RE: **Premier M.H Display Yard
Grading Plan
Engineer's Stamp Date 8/23/17
Hydrology File: M14D012C2**

Based on the information provided in the submittal received on 8/23/17 the above-referenced Grading Plan cannot be approved for Building Permit until the following are addressed:

X-SECTION FOR PNM
SCALE: 1" = 20'

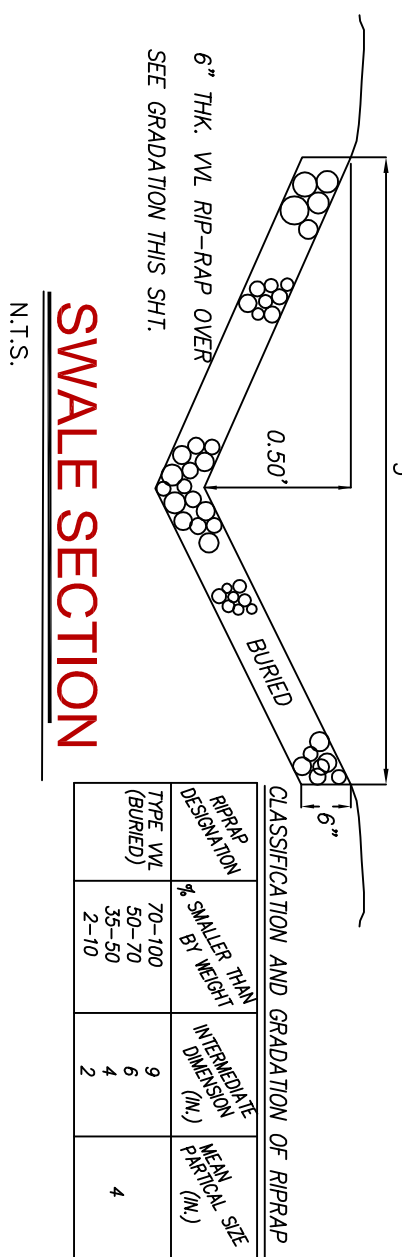
14. Provide written approval (an encroachment agreement) from PNM for the work in their easement. Also show the existing easement on the plan.
15. Provide written authorization from the owners of lot 1-A-2 to remove their wall.

CMU RETAINING WALL @ PL

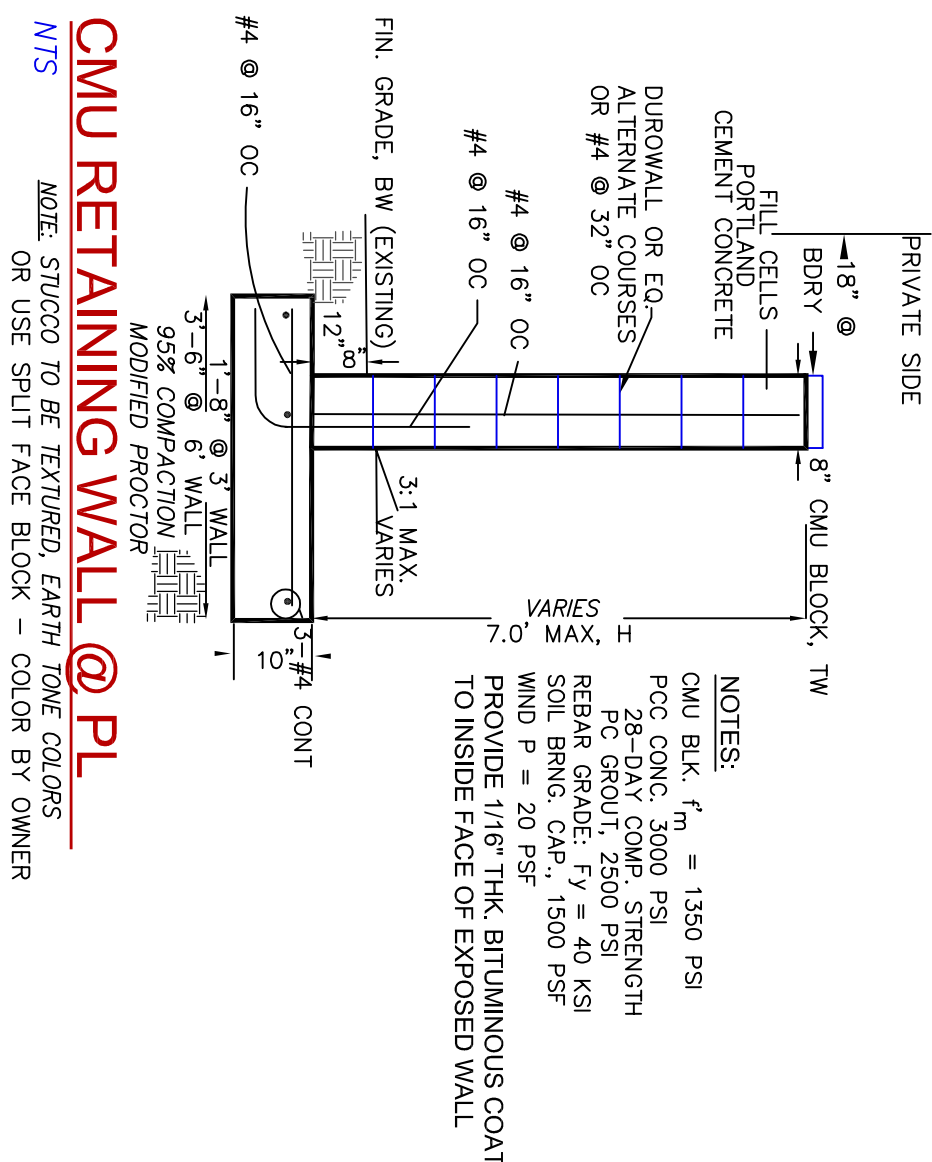
7. Provide pond wall design calculations, sections, details, and construction specifications. Include dimensions to the property line and the depth of the footer below finished grade. None of the wall is allowed in the public right of way. Also include methods of making the wall watertight, and methods to patch/repair cracks. Wrap the wall back to higher ground on the ends and do not attach to adjacent walls.

8. Specify an emergency overflow spillway in the wall and make the rest of the wall higher than the spillway crest. The ends of the wall should be higher than the spillway crest elevation.

GRADING & DRAINAGE PLAN

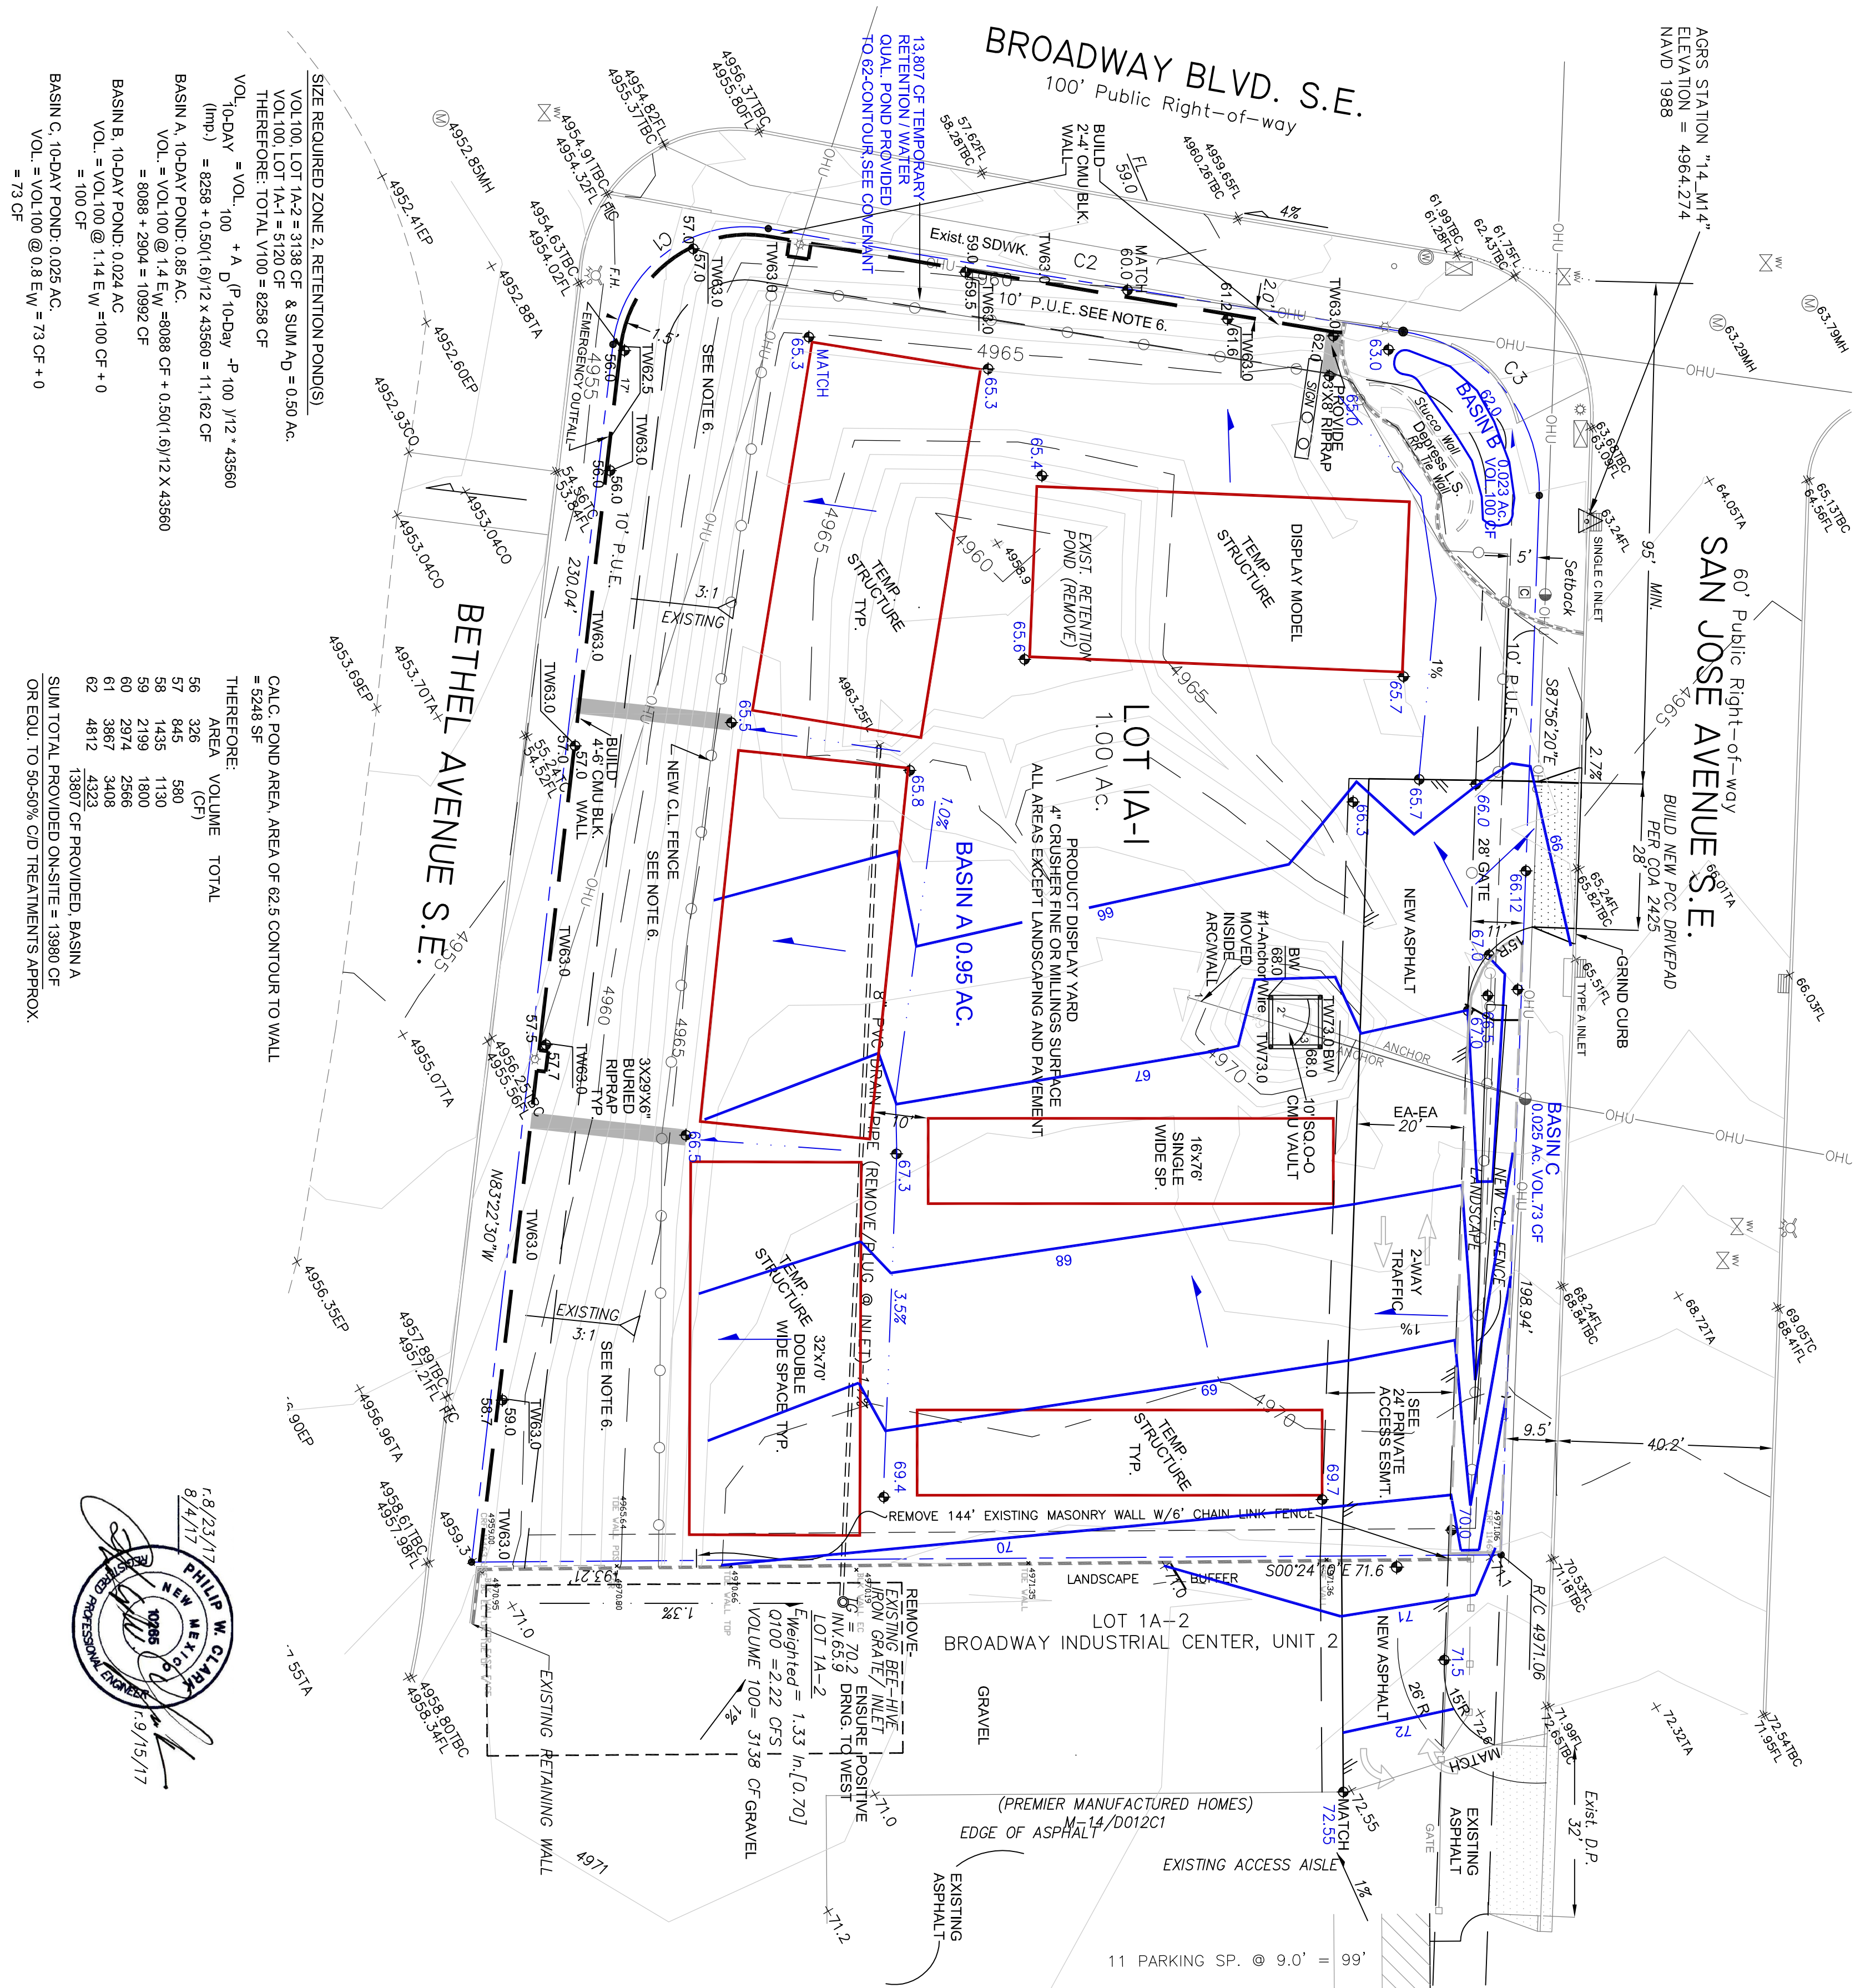
1. The Grading and Drainage Plan notes are still misleading and inaccurate. The statement "Bernalillo County Flood Hazard Ordinance, 2009" is not applicable and should be deleted. The statement "Essentially allowing historic flows to continue to drain through the property" should be replaced with a statement that "by providing a retention pond sized for the 100 year 10 day runoff from both lots 1-A-1 and 1-A-2, totaling 1.65 acres with 75% impervious cover." The statement "Historic site runoff locations will remain unchanged" should be changed to something like "Runoff from Lots 1-A-1 and 1-A-2 will be contained in retention ponds on lot 1-A-1 so that no runoff leaves the site."

2. Under "Calculations" the "Existing Conditions" section is not applicable and should be deleted.
3. Under "Calculations", in the "Design Criteria" section, T_c should be equal to 12 min, instead of 10 min.

5. Under "Calculations- Developed Conditions" use 0.413 ac. treatment C and 1.238 ac. treatment D for a total of 1.65 ac. The 6 hour volume should be 11,215 cf., and the 10 day volume should be 18,406 cf. required. The weighted E is 1.87". The SWQ recommendations can be deleted since the retention pond obviously provides enough volume.

6. Show finished pond contours bold and add spot elevation labels for the finished ground on both sides of the pond wall next to each existing street elevation label. There should be at least 8 label pairs. Add a table of the pond contour areas and volume calculations using the conic equation. Do not include the area between the property line and the inside face of the wall.

9. The statement "All dimensions to face of curb unless otherwise noted" seems out of place in the middle of note 7 under the vicinity map.
10. It is unclear how the inlet on Lot 1-A-2 will drain if the existing 8" drain pipe is removed and plugged. Add construction notes and details of all improvements necessary on both lots to allow the inlet/low spot on lot 1-A-2 to continue to drain into the pond on lot 1-A-1. Show the existing curb on lot 1-A-2, and specify curb cut and/or removal of inlet. Show swale limits on lot 1-A-1 and 1-A-2 all of the way to the existing curb. Show swale hydraulic calculations using flow rates based treatments 25% C and 75% D treatments for both.

11. Offsite basins, lot 1A-2, must be clearly shown on the plan (or on a separate basin map) using a base map that includes property lines contours, and all storm drains, roads, C&G, ditches, and berms as necessary to support the chosen location of the basin boundaries. Flow arrows should be shown on the map indicating concentrated flow paths especially at the point of discharge from each of the basins.
